Rezoning Transportation Analysis

Petition Number: 2022-114

Date	Description
12-28-22	First Review (TM)
03-23-23	Second Review (TM)

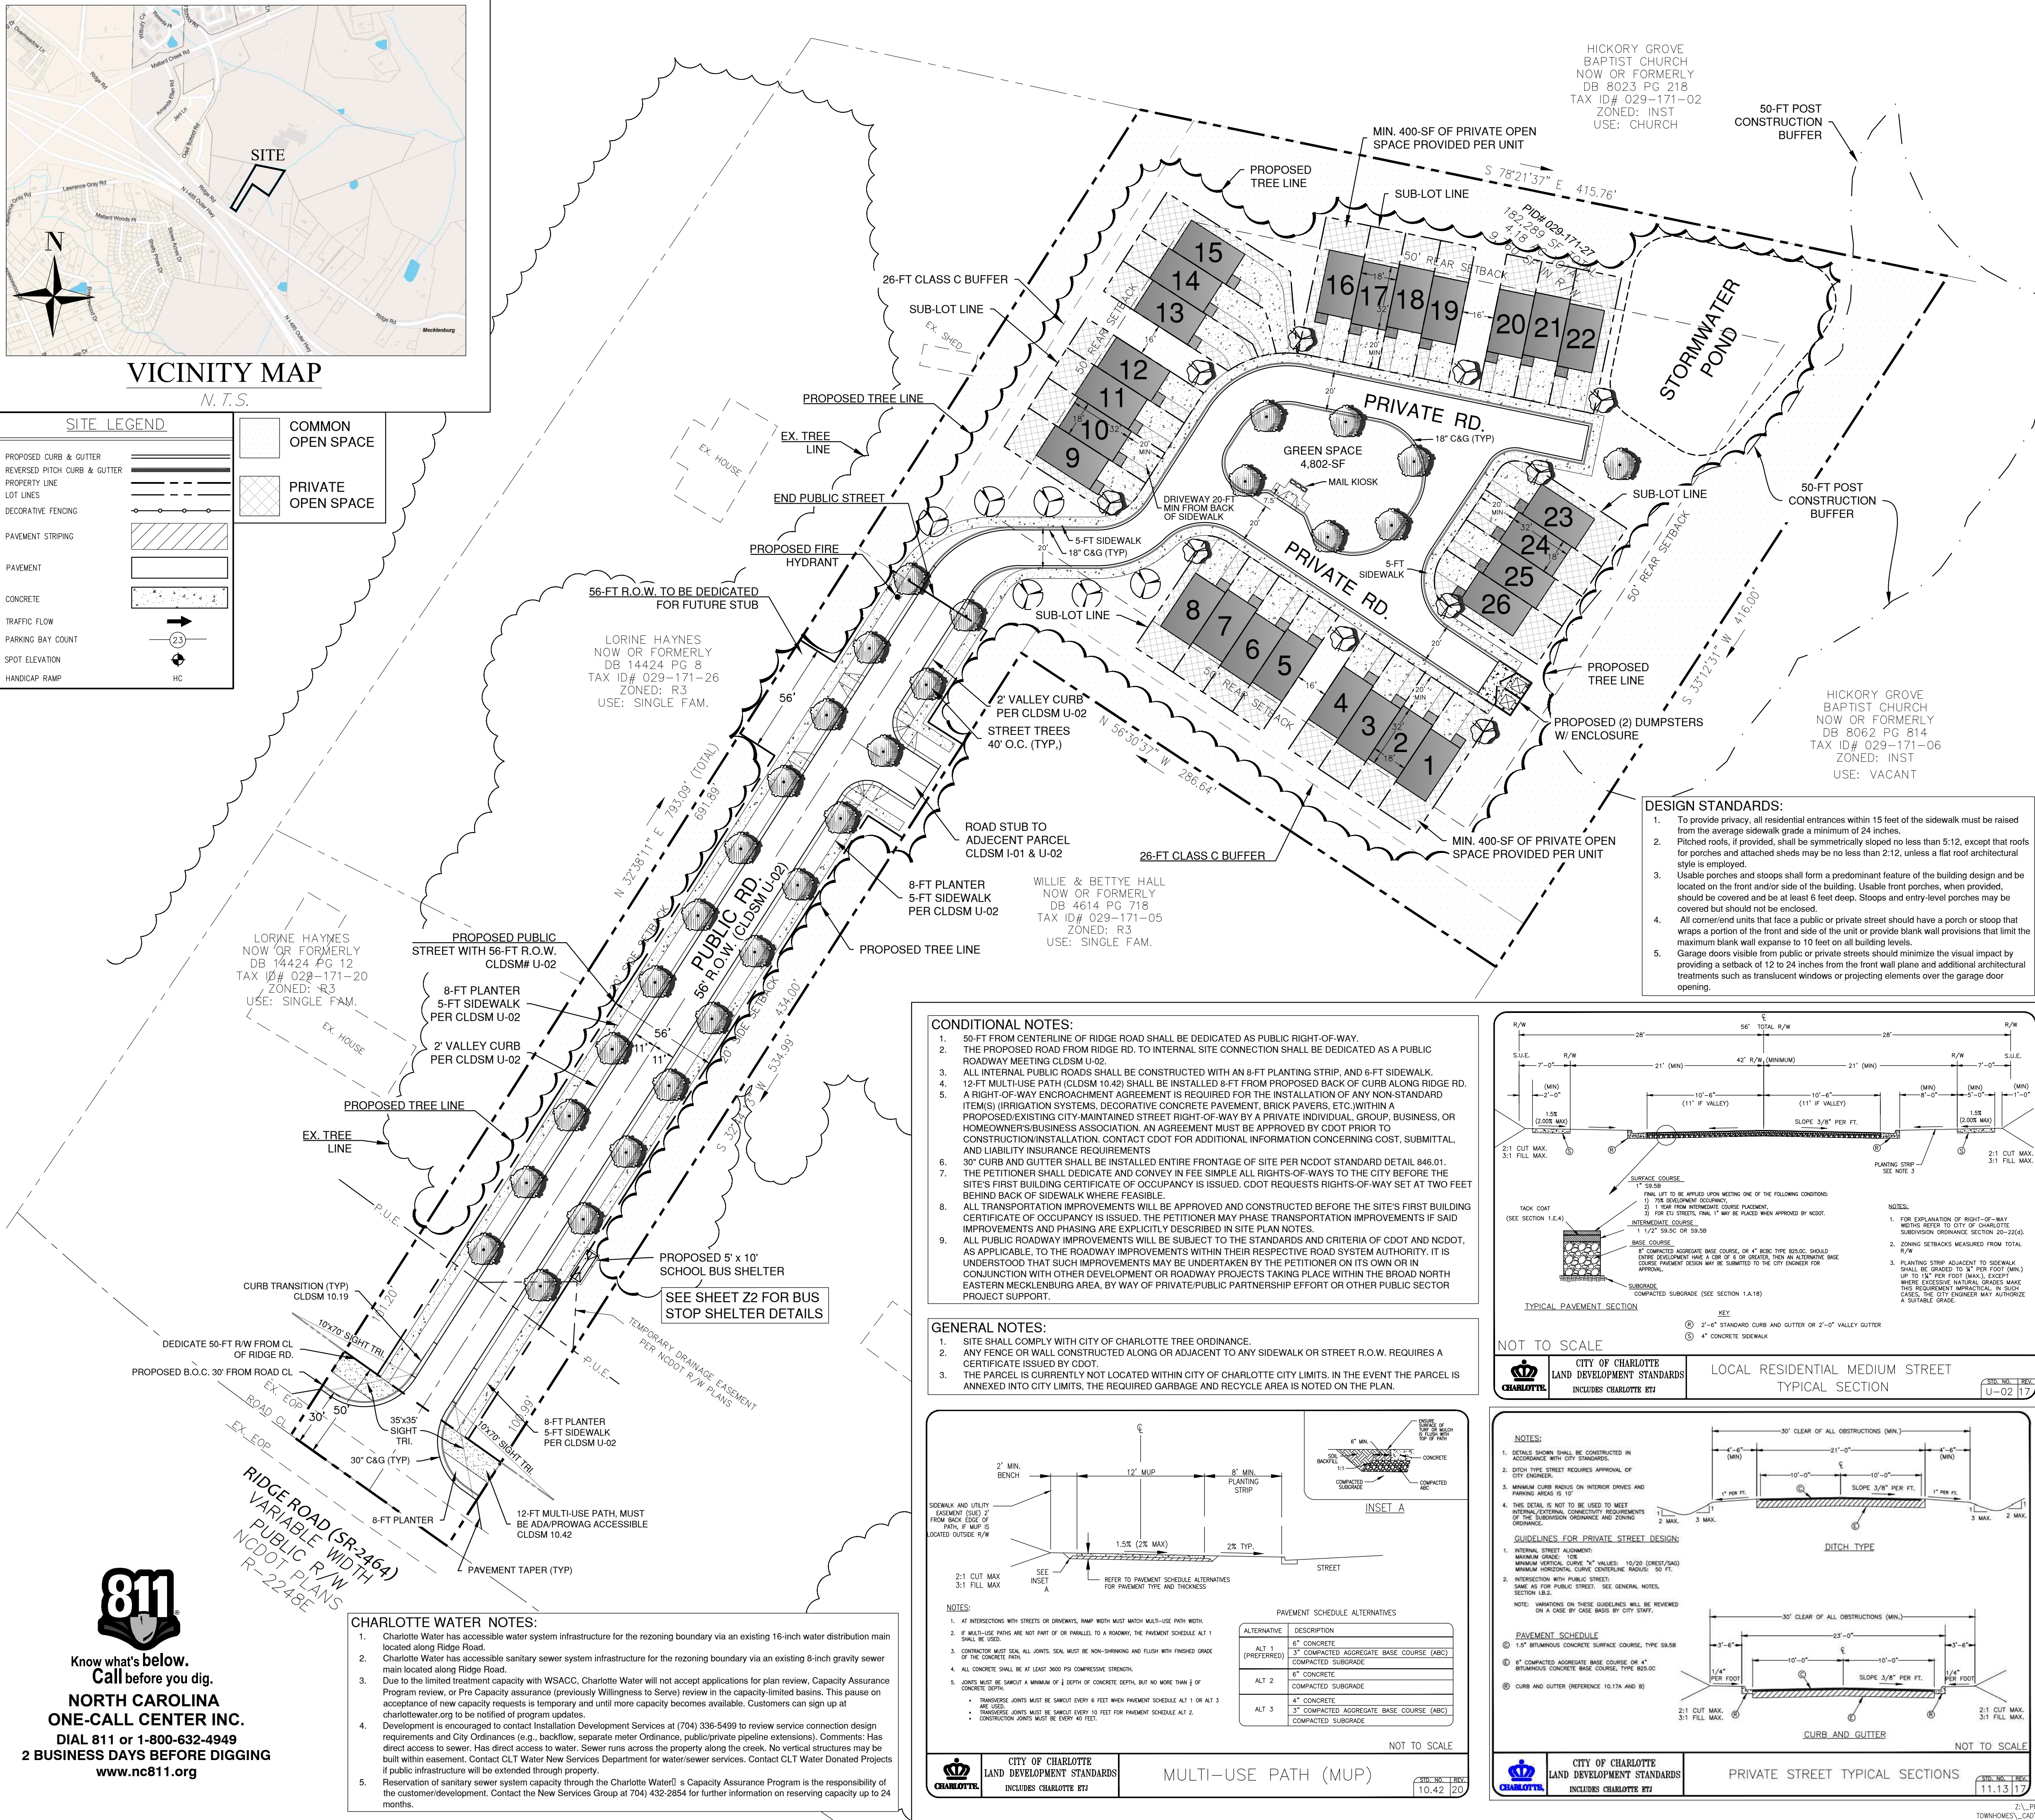
- a. ~~**Ridge Road:** Future back of curb and gutter to be located 30 feet from roadway centerline to accommodate the Charlotte Streets Map with a roadway typical section of CLDSM 11.09 Major Thoroughfare.~~

~~Label and dimension the future curb and gutter from the centerline for each road on the site plan.~~

3. ~~Revise site plan and conditional note(s) to commit to dedicate 50 right-of-way from the road centerline. The site plan shall label and dimension the right-of-way from the road centerline.~~

4. ~~Revise site plan and conditional note(s) to commit to constructing the proposed private road as a public roadway meeting CLDSM U-02 to be dedicated from Ridge Road to the internal site connection. Right-of-way should be dedicated to the property line along this public roadway to provide future access to adjacent parcels.~~

5. ~~Revise site plan and conditional note(s) to commit to construct an 8-foot planting strip, and 6-foot sidewalk on all internal public roads per Chapter 19. The site plan shall label and dimension both items from the back of curb and gutter or edge of pavement.~~

6. ~~Revise site plan and conditional note(s) to commit to construct bicycle facilities by locating the curb and gutter 30' from the center line/installing a 12' multi-use path 8' behind the back of curb to meet the Council-adopted Charlotte BIKES Policy. Multi-use path shall meet ADA/PROWAG requirements.~~

- ~~8. Revise site plan and conditional note(s) to commit to constructing standard 2-foot 6-inch curb and gutter across the entire frontage of the site.~~
